WEST SUSSEX COUNTY COUNCIL CONSULTATION

TO:	Arun District Council FAO: Mr S Davis
FROM:	Emma Avis, Planner, Highways, WSCC
DATE:	20 th December 2018
LOCATION:	Nyton Stables, Nyton Road, Aldingbourne, Chichester, PO20 3TX
SUBJECT:	AL/107/18/PL Application for continued use for 3 No. approved permanent showpersons plots (temporary permission granted under AL/119/10/ & permanent permission granted under AL/10/14/PL), planning permission for a further 8 No. plots consistig of 4 No. existing & 4 No. new plots (to a maximum of 11 plots) with associated hard & soft landscaping, boundary treatment, lighting & associated works.
DATE OF SITE VISIT:	
RECOMMENDATION:	☐ Advice ☐ Objection ☐ Modification ☐ No Objection ☒ More Information ☐ Refusal
S106 CONTRIBUTION TOTAL:	£N/A See below for breakdown.

Title
PROPOSED SITE PLAN

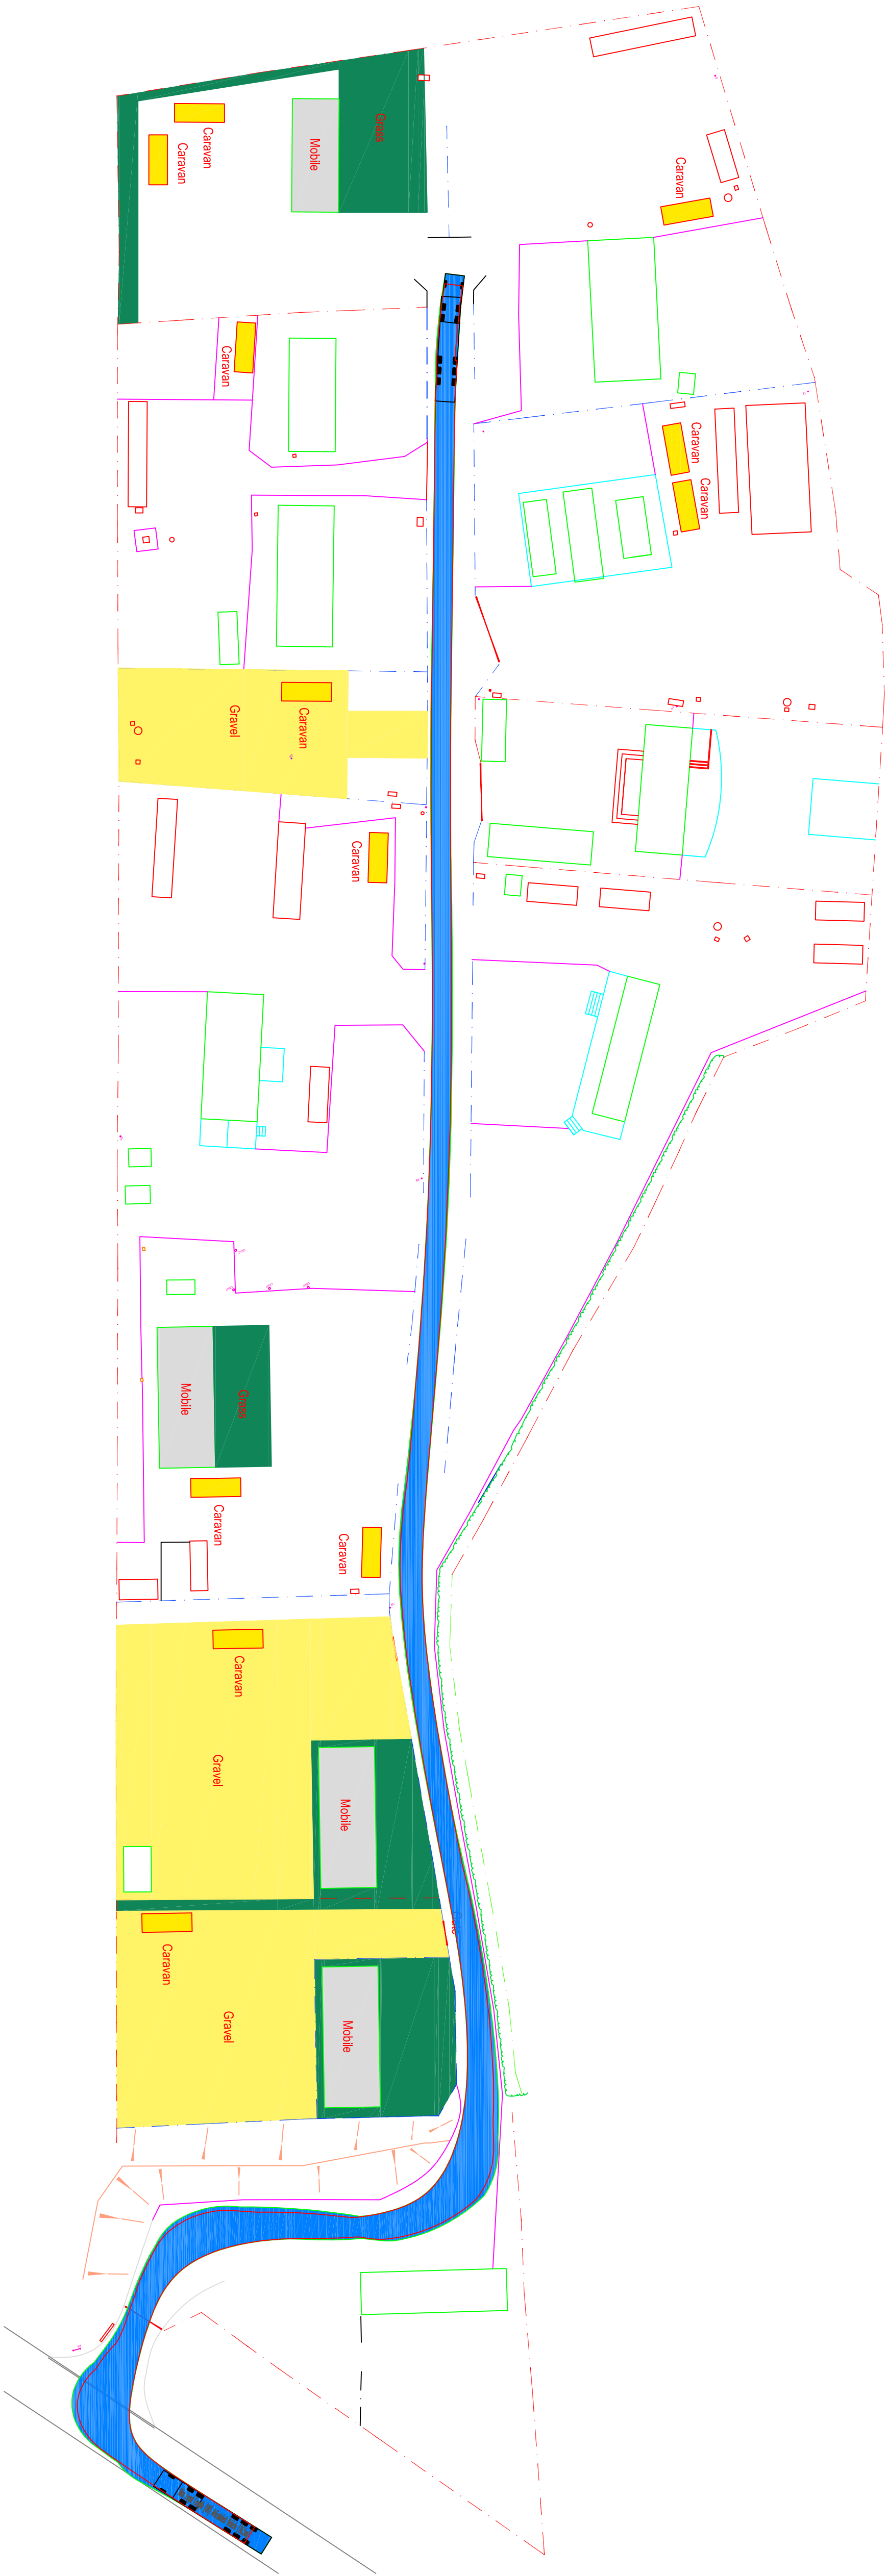
- Clarification on the increase in vehicle movements (existing/proposed)
- Tracking plans demonstrating that the existing access is capable of accommodating the largest vehicle that is expected to enter and exit the site. It is noted that the access is existing but it only has permission to serve 3 plots and this permission was granted some time ago. Given the increase in use that is proposed the access needs to be assessed for intensification of use.
